Engineers Comments Regarding Surface Water Drainage

Application Reference:	WA/106/24/DOC	Reviewer Reference:	ADC/EXT2/D2134/68
Planning Officer:	Kathryn Welch	Date of Review:	08.08.2025
Site Name:	Land East of Tye Lane Walberton		
Application Description:	Approval of details reserved by condition imposed under reference WA/124/23/S73 relating to condition number 23(b) - SuDS System, and condition number 25(b) - SuDS Maintenance Manual.		
Assessment Number:	1 of 2

Summary and Recommendation:

As Constructed Survey

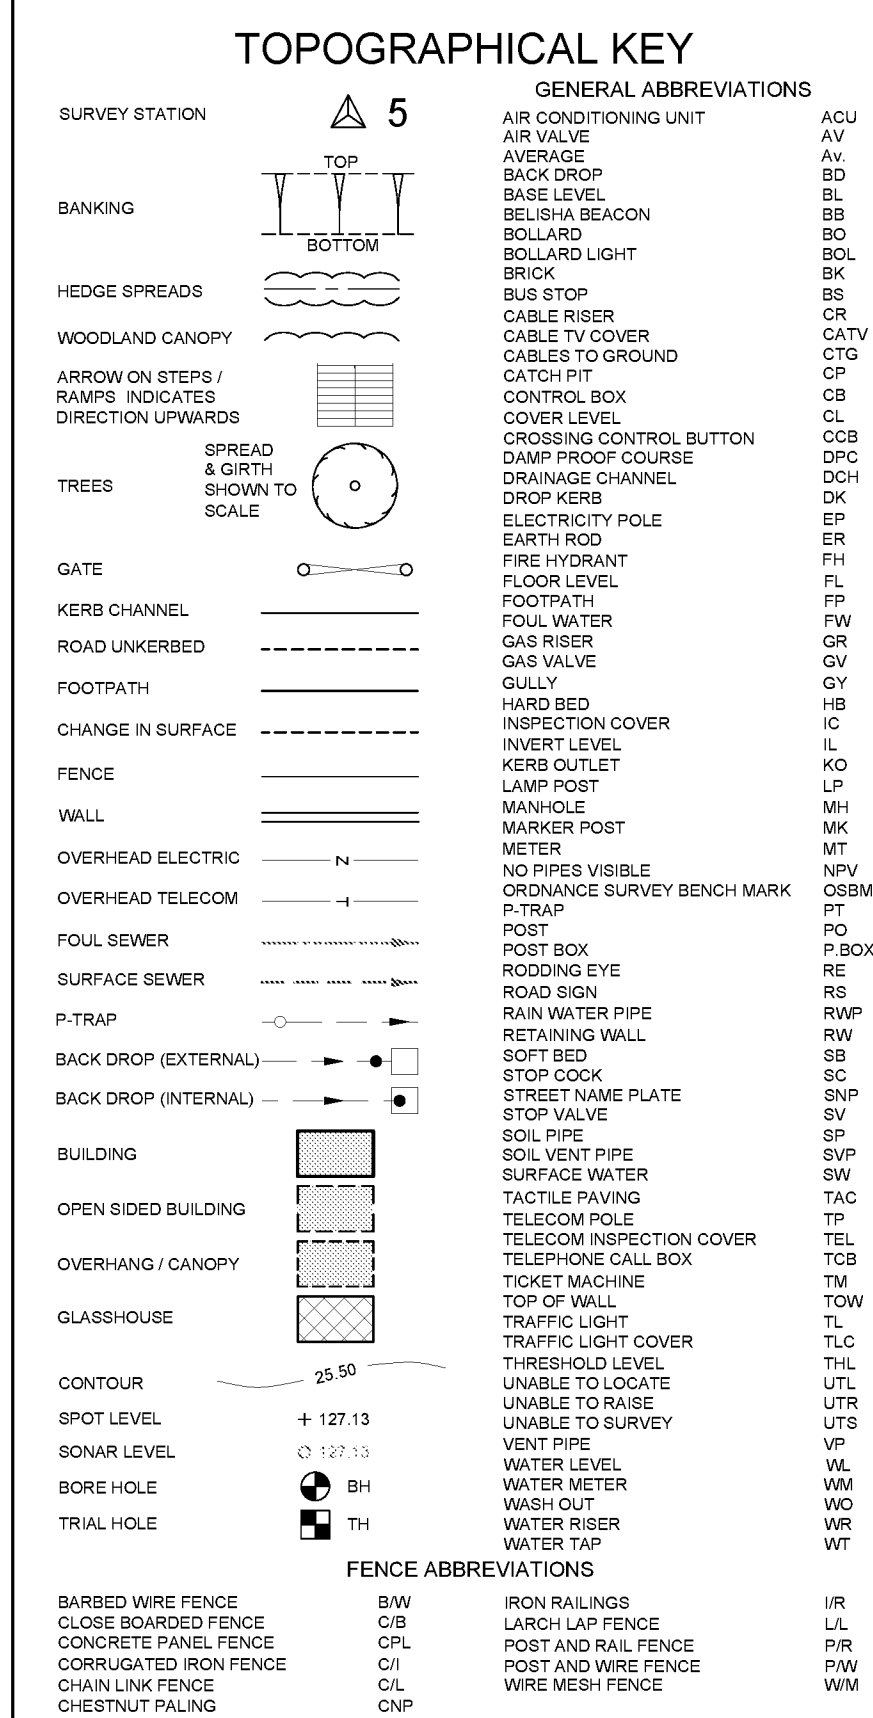
8.	The report should include an As Built survey to the requirements listed in ADC verification guidance note. It is recommended that the author reviews this list and arranges the revised report accordingly.	Appendix D provides an as-built topographical survey however this only captures the swales and basins for phase 1. Comprehensive evidence for phase 2 is required. Evidence must be provided to ascertain if the FFL's for plots, roads and how they compare to the SUDS permeable pavement and to ensure no increase in flood risk.	Added to appendix F.	Noted. The west basin design base was 12.01m and the as-built shows this to be 12.36-11.73m which matches or is deeper thus is accepted. The east basin design base however was 13.7m and the as-built shows this to be 14.25-14.49m therefore or not in accordance with the approved design and may provide insufficient storage. Please advise. Comment outstanding.
